Your ref:
My ref: P23/00365

10 Abercorn Close, London, NW8 9XS,

Partial demolition of the rear elevation and rebuilding of facade incorporating a solar shading system, glazed walls and Juliette balconies.

drawing title: **Proposed First Floor Plan**

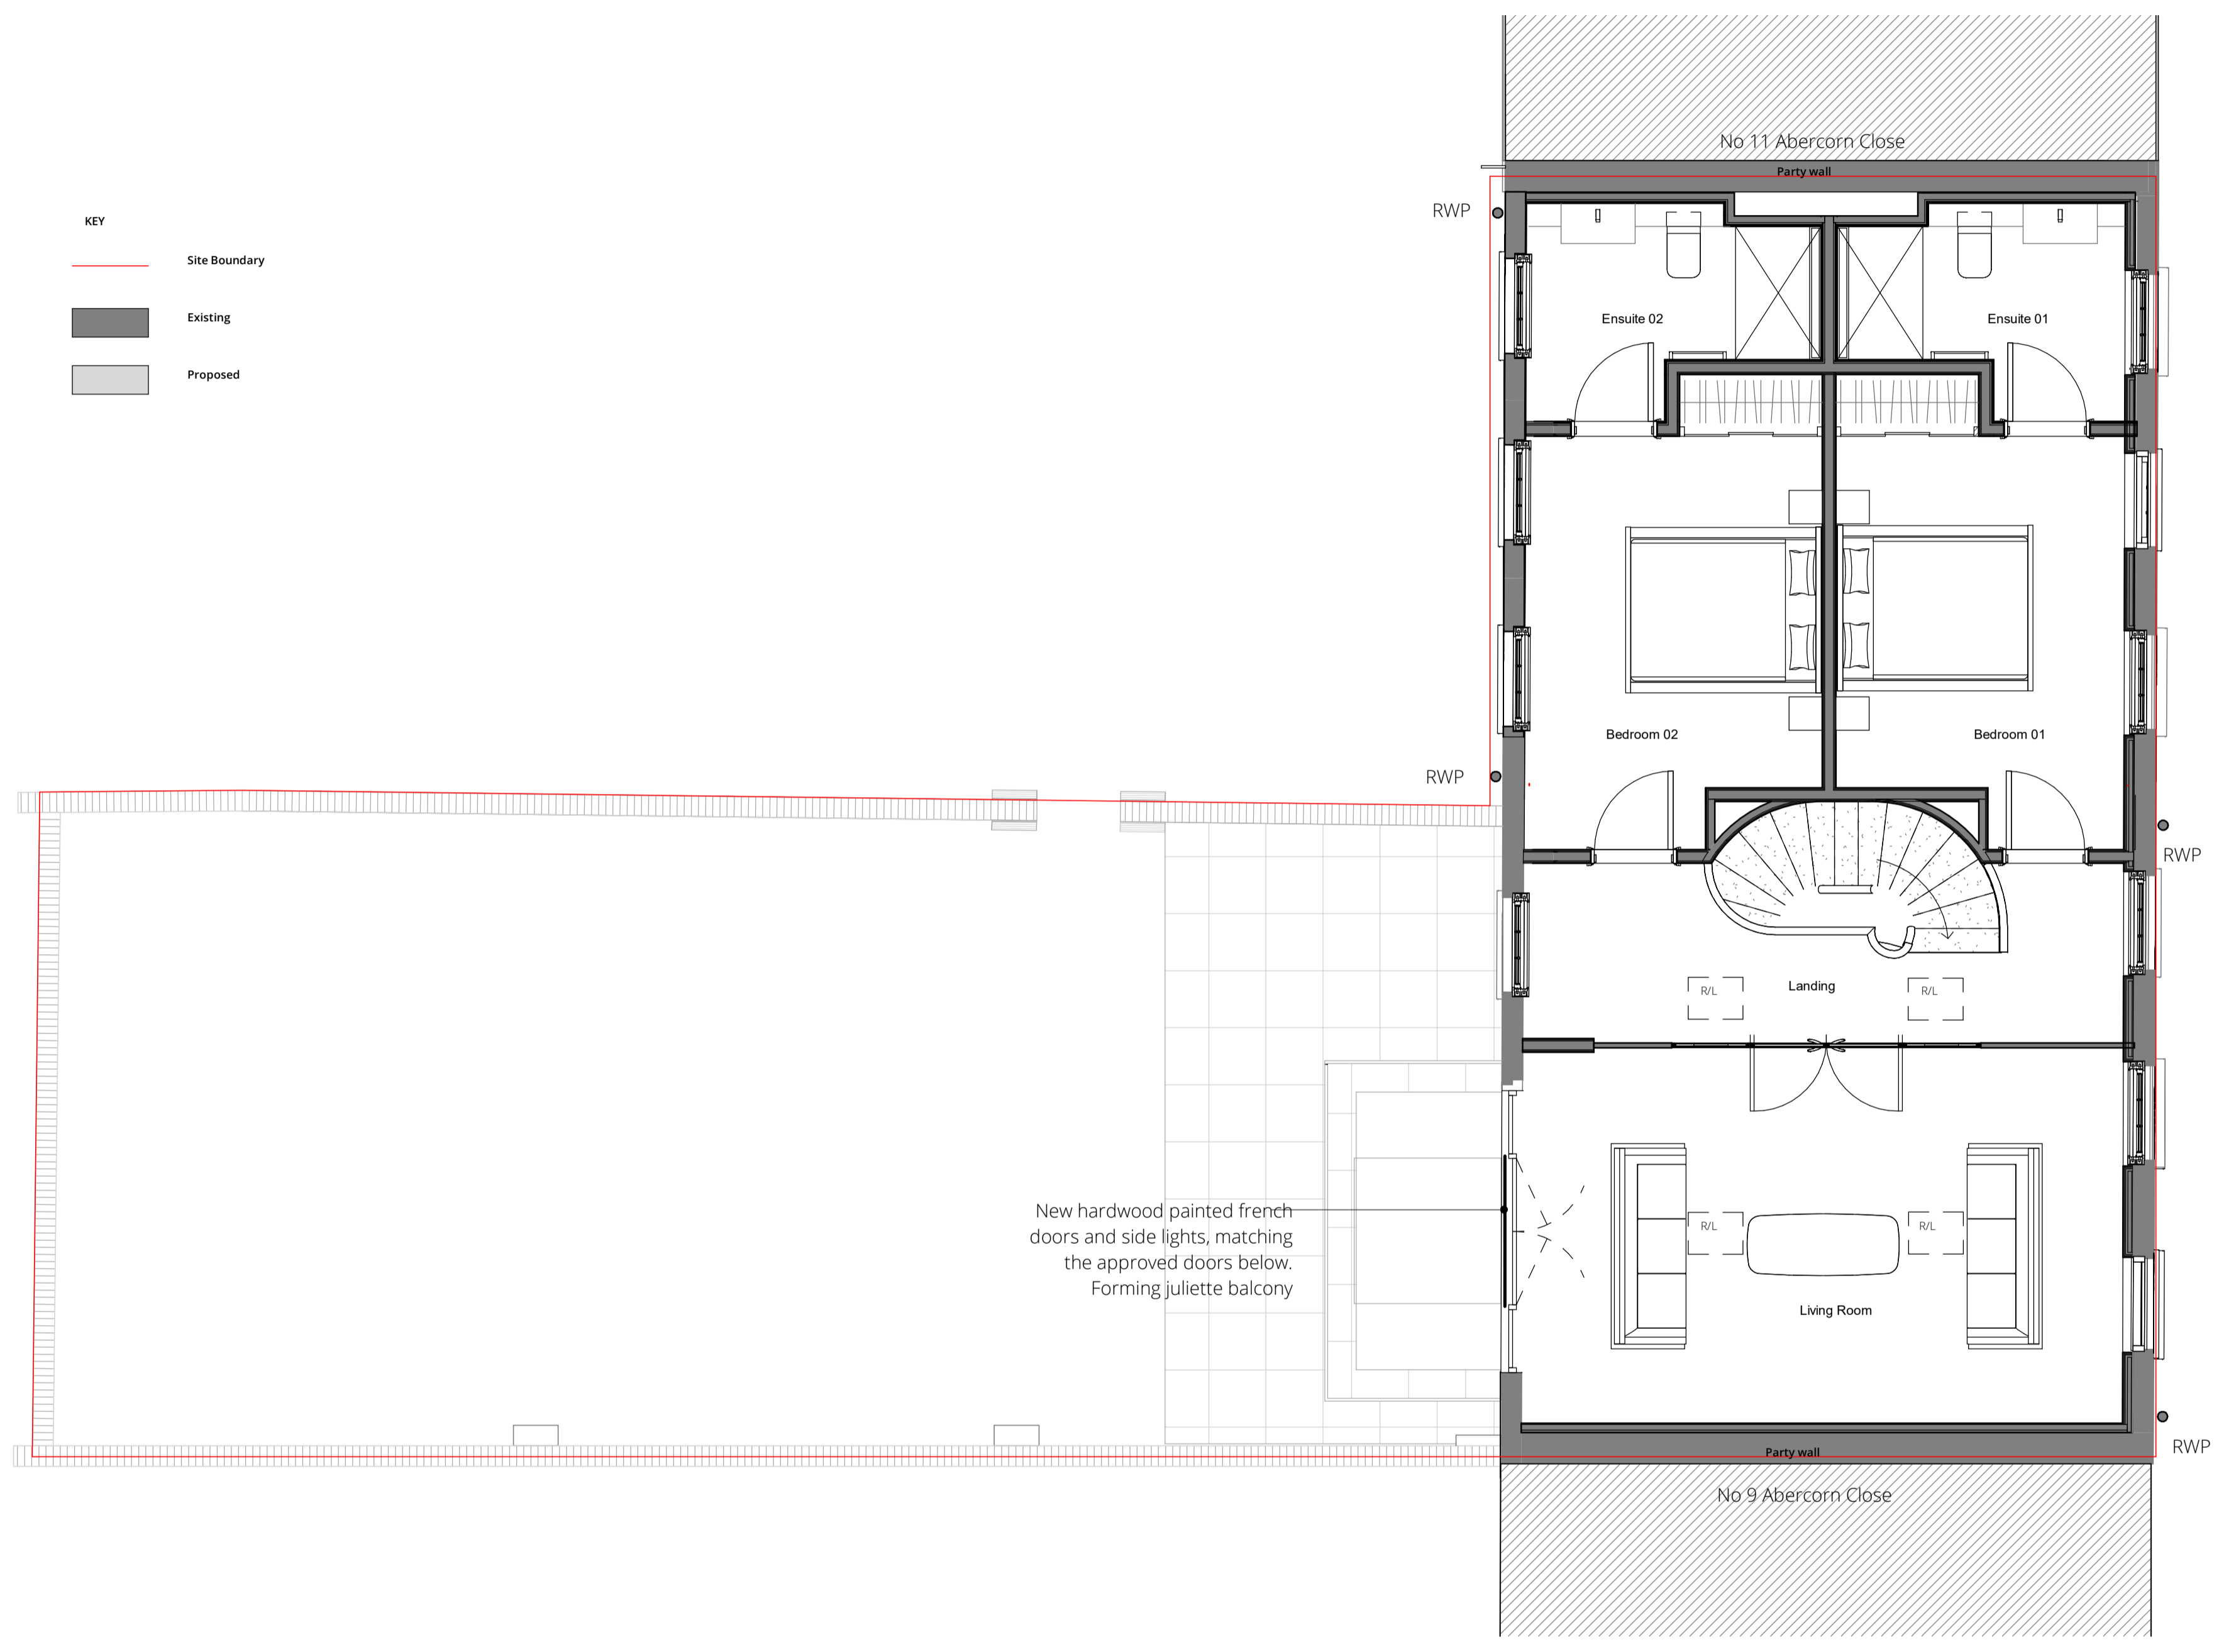
Openings at first floor level to the rear elevation are not uncommon, therefore, subject to design, given their location and size of the opening, the discreet Juliette balconies at first floor level serving the living room and bedroom 2 are unlikely to result in loss of privacy. The site backs onto no.104 Hamilton Terrace and also given the proximity (27m) between the application site and no.104 Hamilton Terrace, this element is not contentious in amenity terms.
